**RE: SECTION 96(1A) MODIFICATION  
BLOCK 4S CENTRAL PARK (SSD5700)**

This application has been prepared by Ethos Urban on behalf of Multiplex Constructions Pty Ltd pursuant to section 96(1A) of the *Environmental Planning and Assessment Act 1979* (EP&A Act) to modify Development Consent SSD 5700 relating to Block 4S Central Park (the site).

The modification relates to minor amendments to the public domain associated with the building, in the through-site link between Block 4S and Block 4N (note – no modifications to Block 4N SSD 6673). The modification includes the deletion of three planter boxes within the public domain in order to provide access and ventilation to High Voltage Cable Chamber room servicing Block 4N.

GROUND & LEVEL 00 PLAN

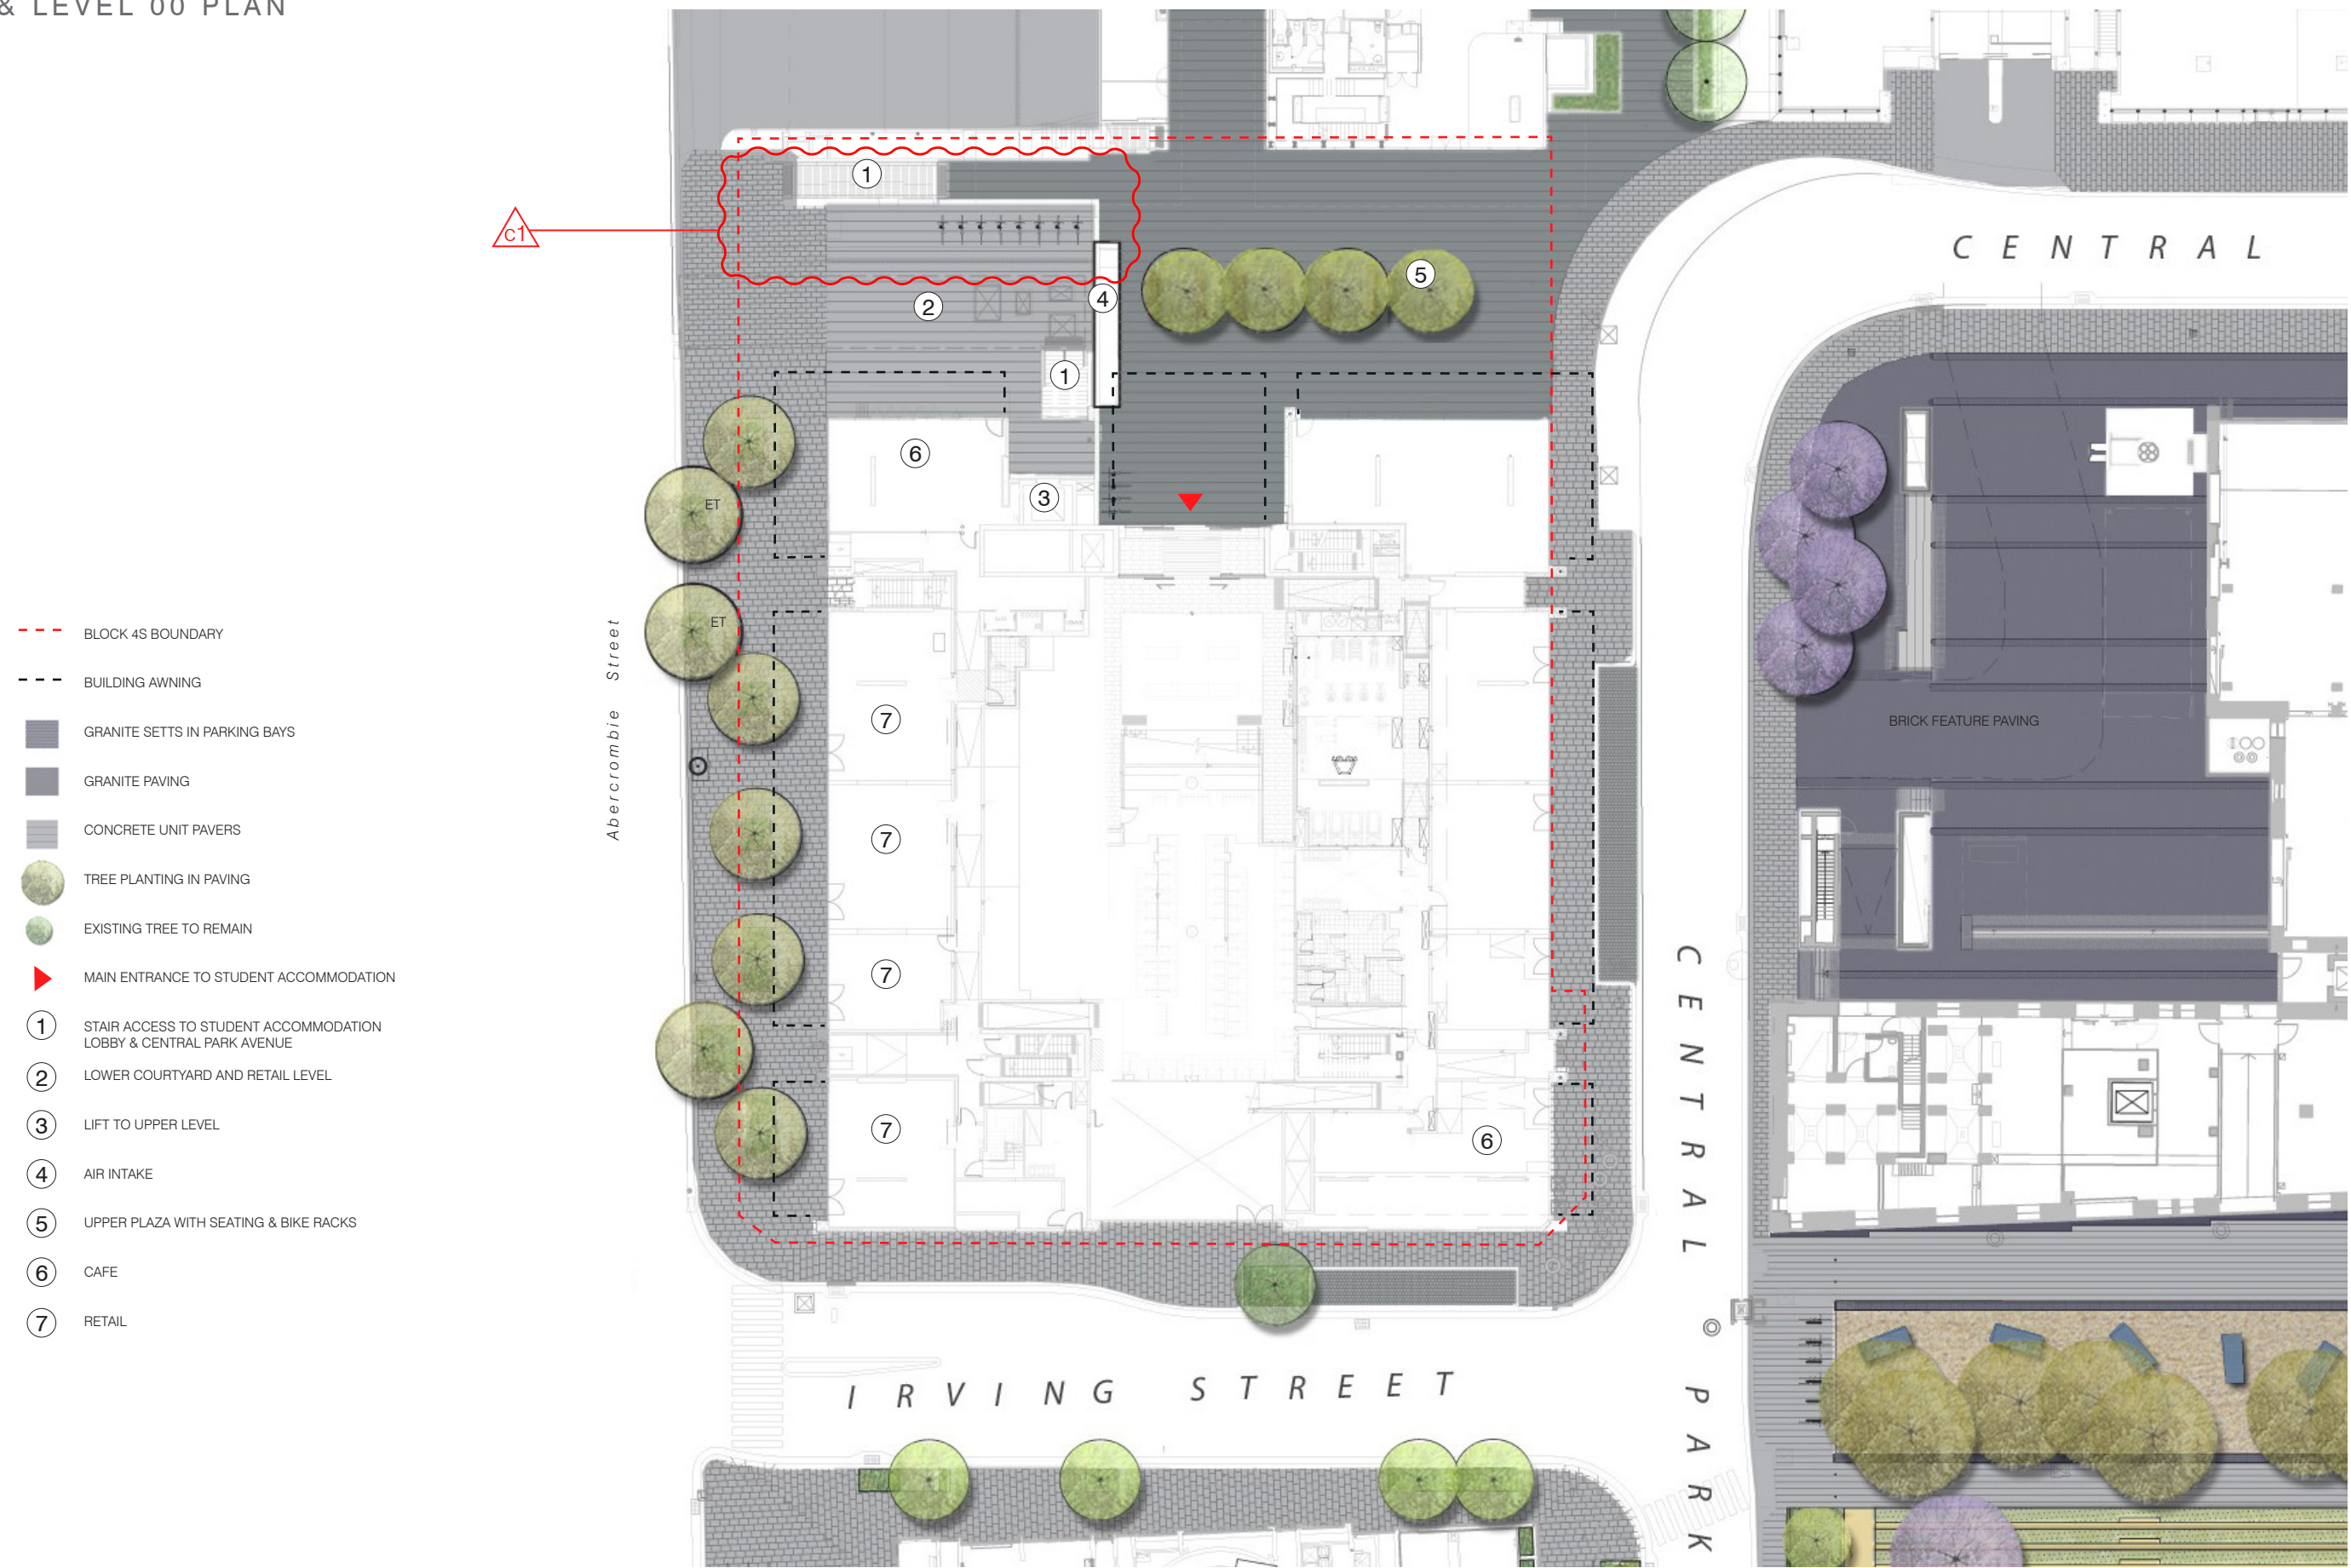
The modifications relate to amendments to the public domain and landscaping to the north of Block 4S, within the through-site link between Block 4N and Block 4S (connecting Abercrombie Street/Central Park Avenue). The modifications include the deletion of five planter boxes within the public domain. A location plan is shown at **Figure 1** and a comparison of the approved development and proposed modifications are shown at **Figure 2**.

The approval of Block 4N and its associated infrastructure has led to the need for access, ventilation and servicing requirements to the area. The High Voltage Cable (HVC) Chamber, located in the Block4N Basement required a path of egress and access hatch. Installation of planters as proposed in this area would fault this egress requirement to the Chamber (refer to **Figure 3**).

Additionally, any drainage to these planter boxes would encroach on agreed Ausgrid deed for servicing to the Block 4N HVC. Finally, relocating similar planters anywhere south of the current approved location will provide further complications, as no drainage would be able to be reticulated under the existing constructed slab, as there is another HVC (for 4S) in the location below.

Drawing Number	Revision	Name of Plan	Date
<b>Architectural (or Design) Drawings prepared by Foster + Partners</b>			
...			
PA-A-5759	<del>08</del> 09	Level Ground Floor	<del>20/05/13</del> 02/02/18
...			
<b>Landscape and Public Domain Drawings prepared by Jeppe Aagaard Anderson &amp; Turf Design Studio</b>			
4	<del>B</del> C	Ground Floor & Level 00 Plans	<del>12/12</del> Feb 2018
